KIRKLEES METROPOLITAN COUNCIL INVESTMENT & REGENERATION SERVICE

DELEGATED DECISION TO DETERMINE APPLICATIONS FOR CONSENT, AGREEMENT OR APPROVAL REQUIRED BY CONDITION

Reference No:	2025/44/90689/W
Site Address:	Penistone Road/, Rowley Lane, Fenay Bridge, Huddersfield, HD8 0JS
Description:	Discharge of details reserved by conditions 16 (temp drainage), 25 (retaining walls), 26 (surface water attenuation pipes), 31 (road network) on previous permission 2020/92307 for outline application, including the consideration of access, for erection of residential development (up to 75 units)
Recommending Officer:	Katie Chew

DECISION – Discharge of Condition – Split Decision

DRAWING TITLE: FENAY BRIDGE, HUDDERSFIELD (TANK 2)
2.0m Dp. MODULAR WATER
RETAINING TANK
PROPOSAL DRAWING

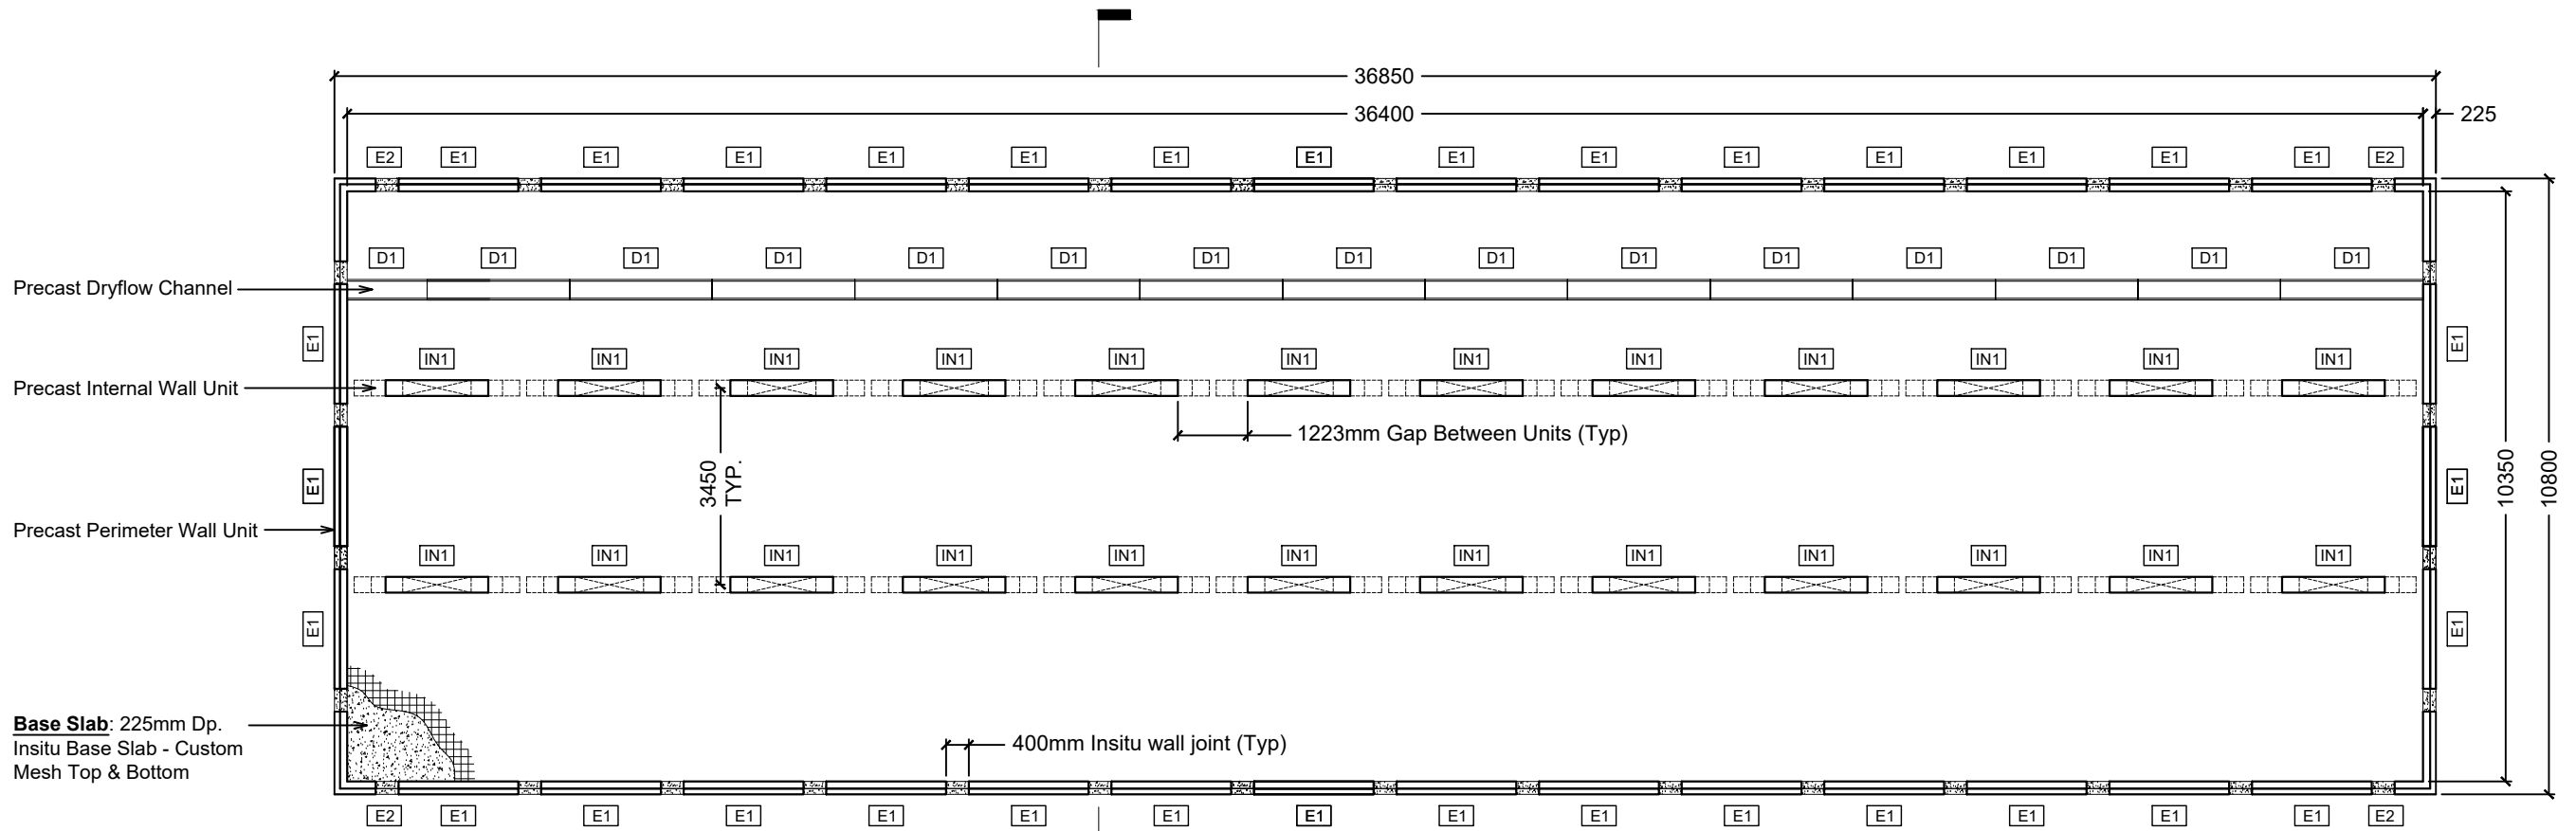
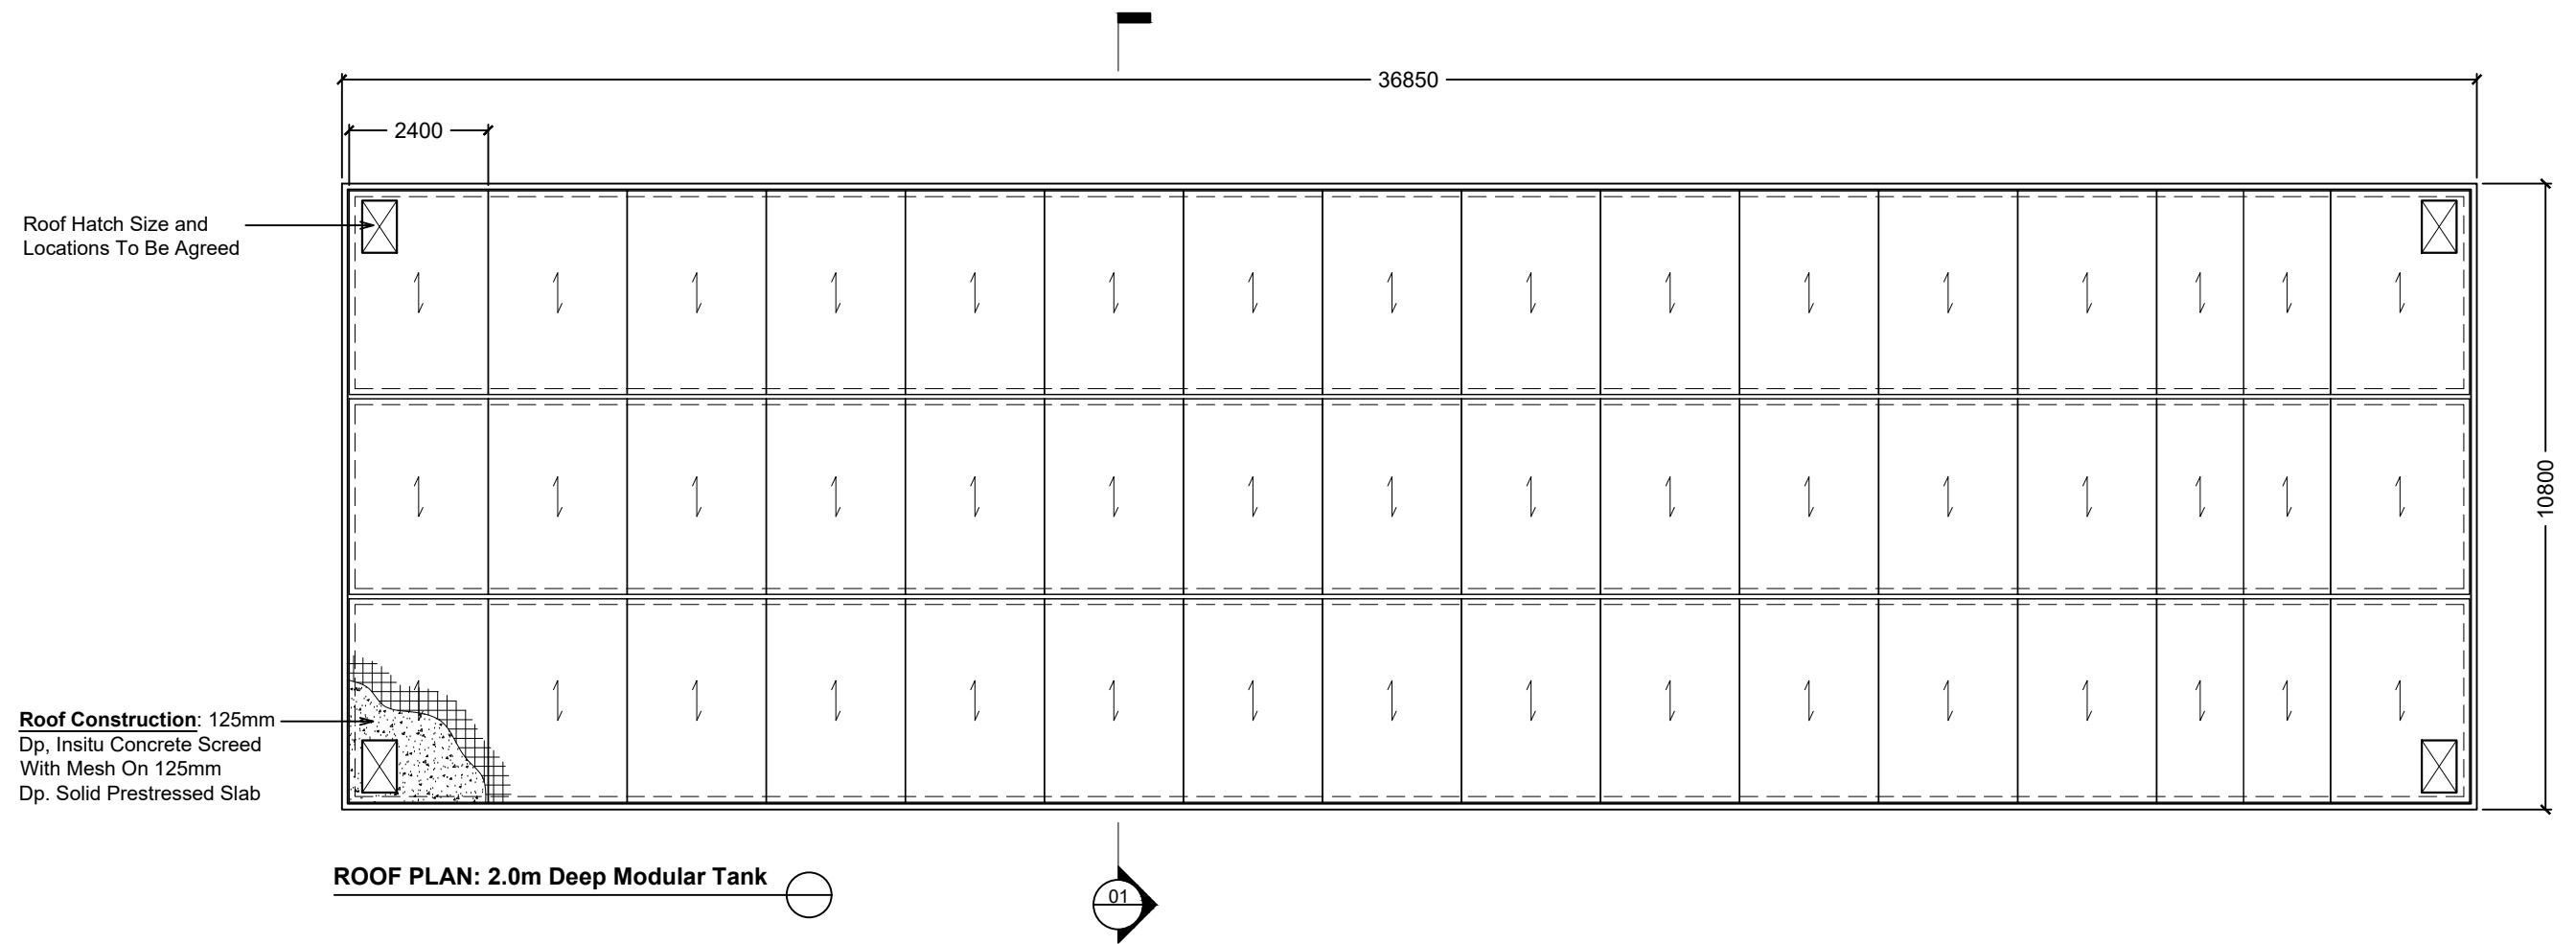
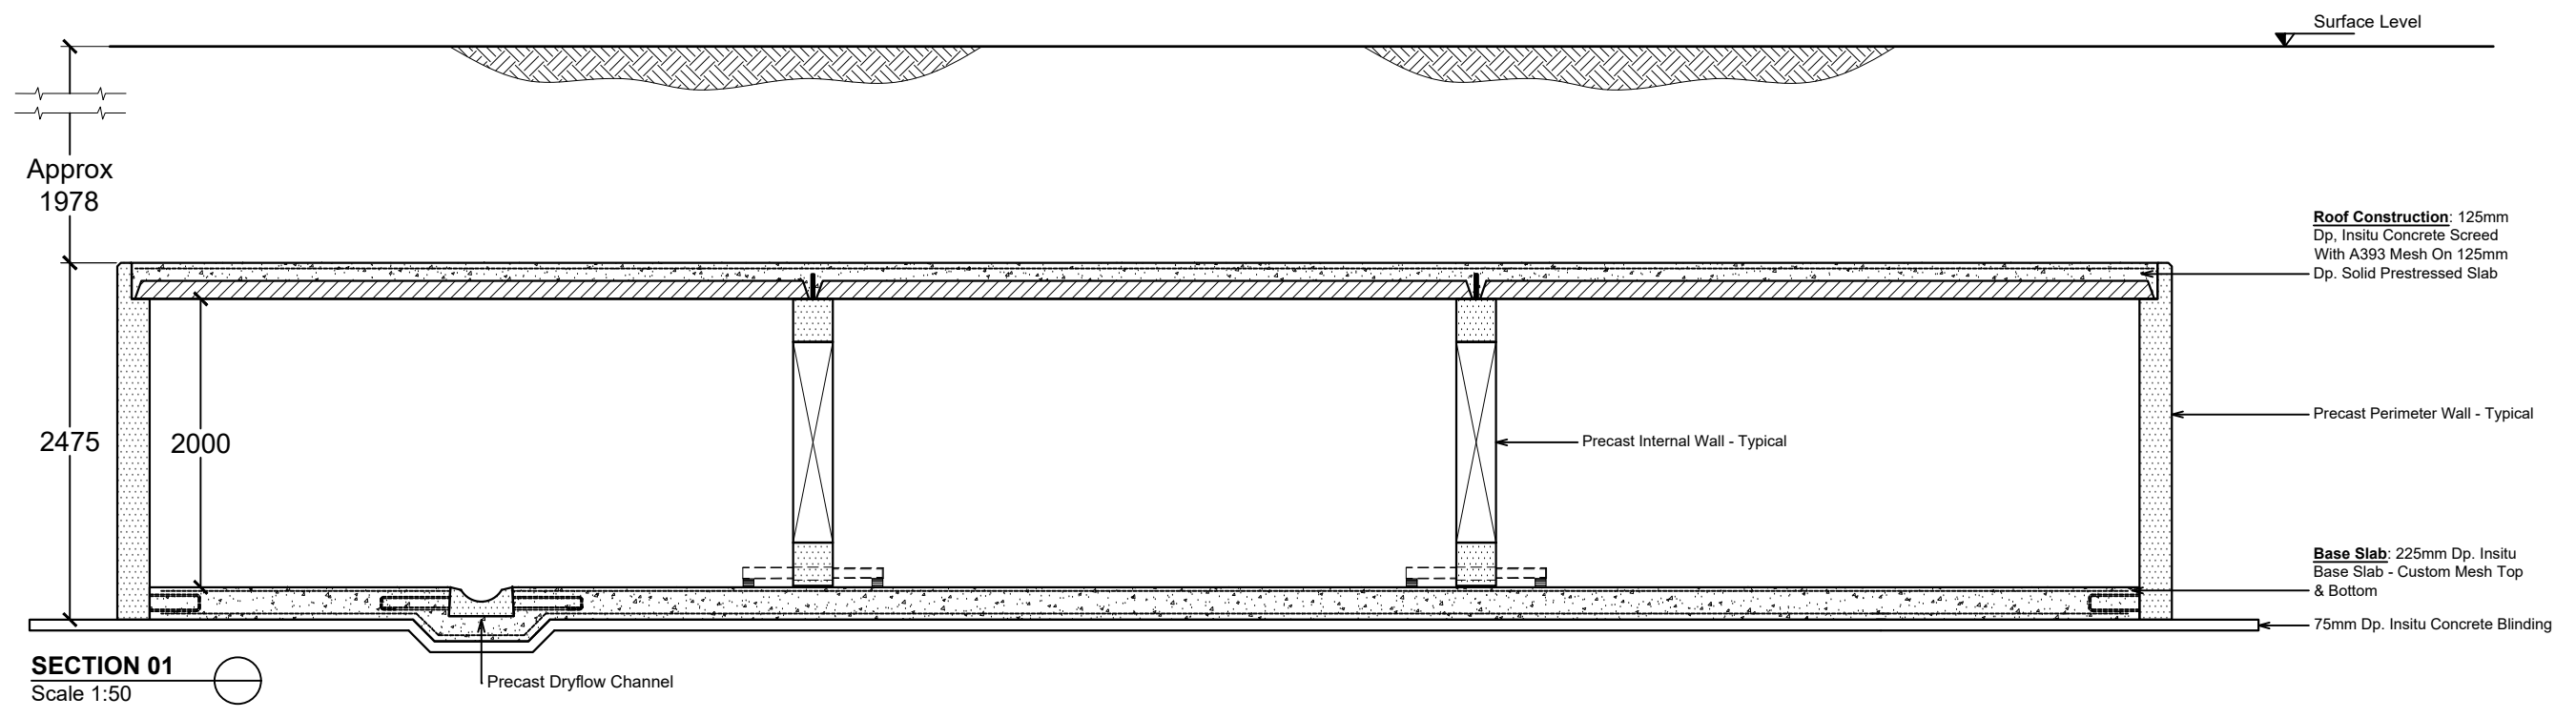
2) Suitably scaled and fully dimension X-sectional detail between the attenuation tank and the adjoining highway adjacent to plot 48 to ascertain whether the design of attenuation tank wall will be liable to a formal technical approval via submission of an AIP.
